**KIRKLEES METROPOLITAN COUNCIL
INVESTMENT & REGENERATION SERVICE**

**DELEGATED DECISION TO DETERMINE PLANNING APPLICATIONS TO
CARRY OUT DEVELOPMENT WITHOUT COMPLIANCE WITH PLANNING
CONDITIONS PREVIOUSLY ATTACHED**

Reference No:	2025/70/92994/E
Site Address:	Nelson Inn, 145, Slaithwaite Road, Thornhill Lees, Dewsbury, WF12 9DW
Description:	Variation of condition 2 (plans) on previous permission 2022/92094 for demolition of public house and erection of education centre and prayer room
Recommending Officer:	Jennifer Booth

DECISION – Variation of Condition - Approved

DRAWING TITLE:
Proposed Design

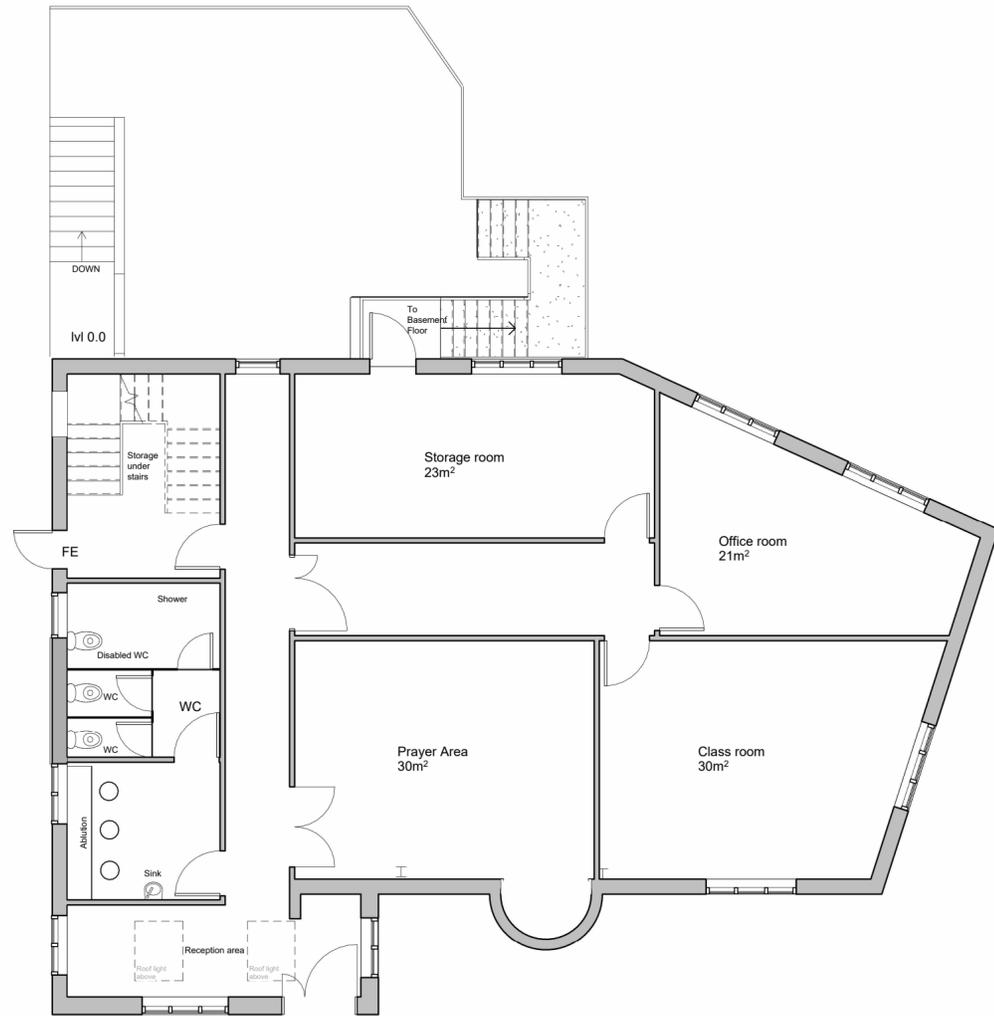
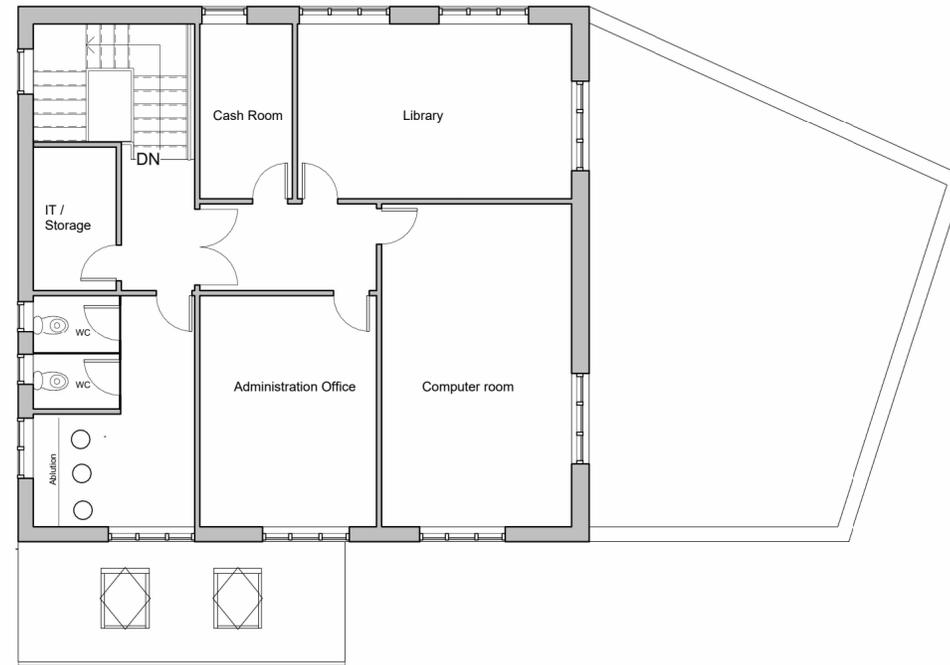
- Double pitched roof replaced by one single pitched roof.
- Alterations to window and door fenestration.
- Currently the front porch area has been constructed taller with lean to roof design however this element will be reduced to the previously approved size as shown on the submitted plans. The windows and door position however will change to align with upper floor opening.
- Semi-circular niche (mihrab) to front elevation
- Due to the fenestration the internal layout of rooms has slightly changed, nevertheless the prayer room size remains similar with no impact on occupancy as previously conditioned.

DRAWING TITLE:
Proposed Design

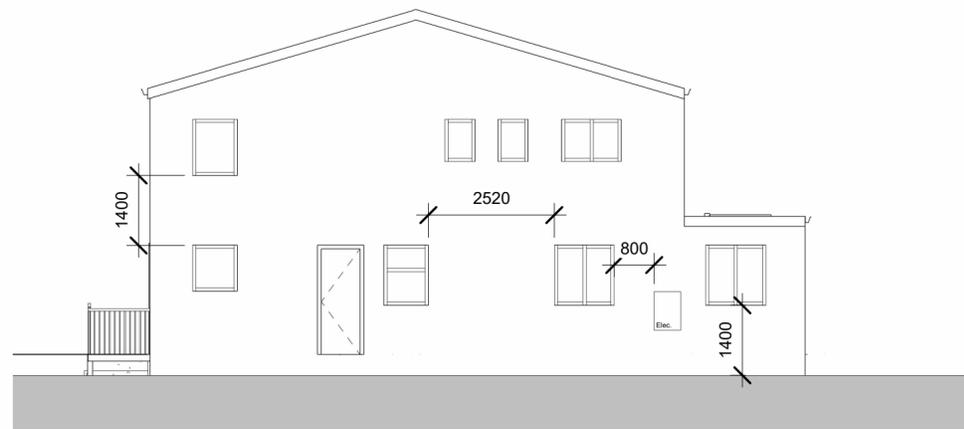
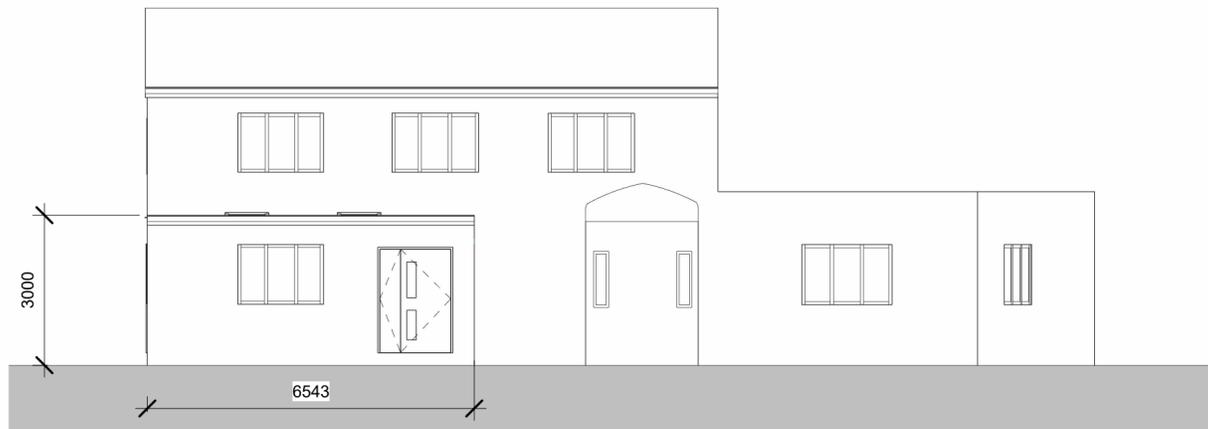
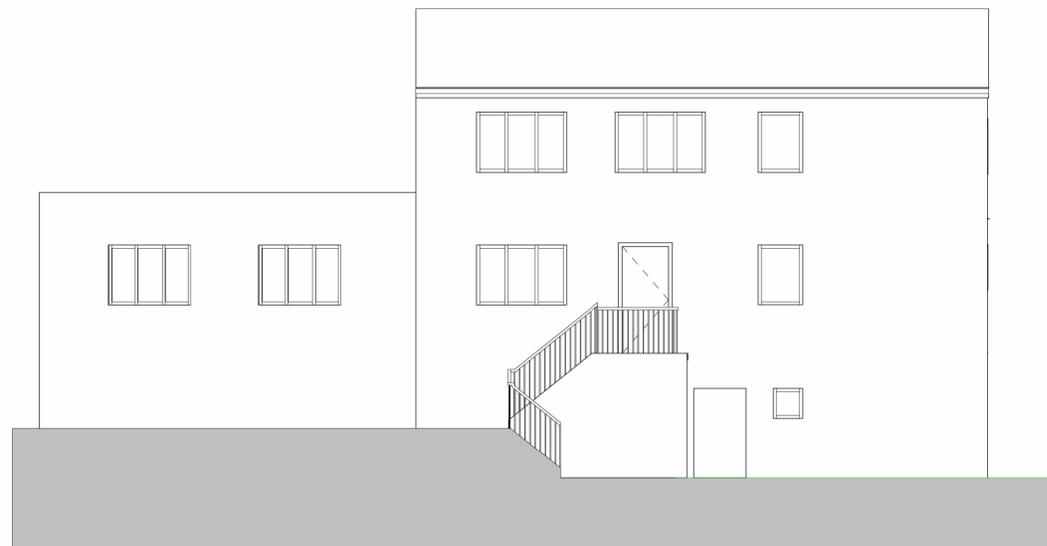
The 2021 planning approval for replacing the original public house permitted an increase in the building's height while maintaining its original proportions and the low-level appearance provided by the dual-pitched roof over the two-storey element. A previously refused variation sought to widen the first floor above the single-storey section and replace the roof with a single pitch of significantly greater height, which would have resulted in a substantial increase in bulk and massing on this prominent and modest plot.

The current variation proposal still includes a pitched roof; however, the overall height has been reduced compared to the earlier refused variation proposal. Additional changes include the formation of a mihrab, modifications to the front extension, fenestration adjustments, and internal layout alterations. Given the reductions from the previous refusal variation, and the nature of the amendments, these are considered acceptable.
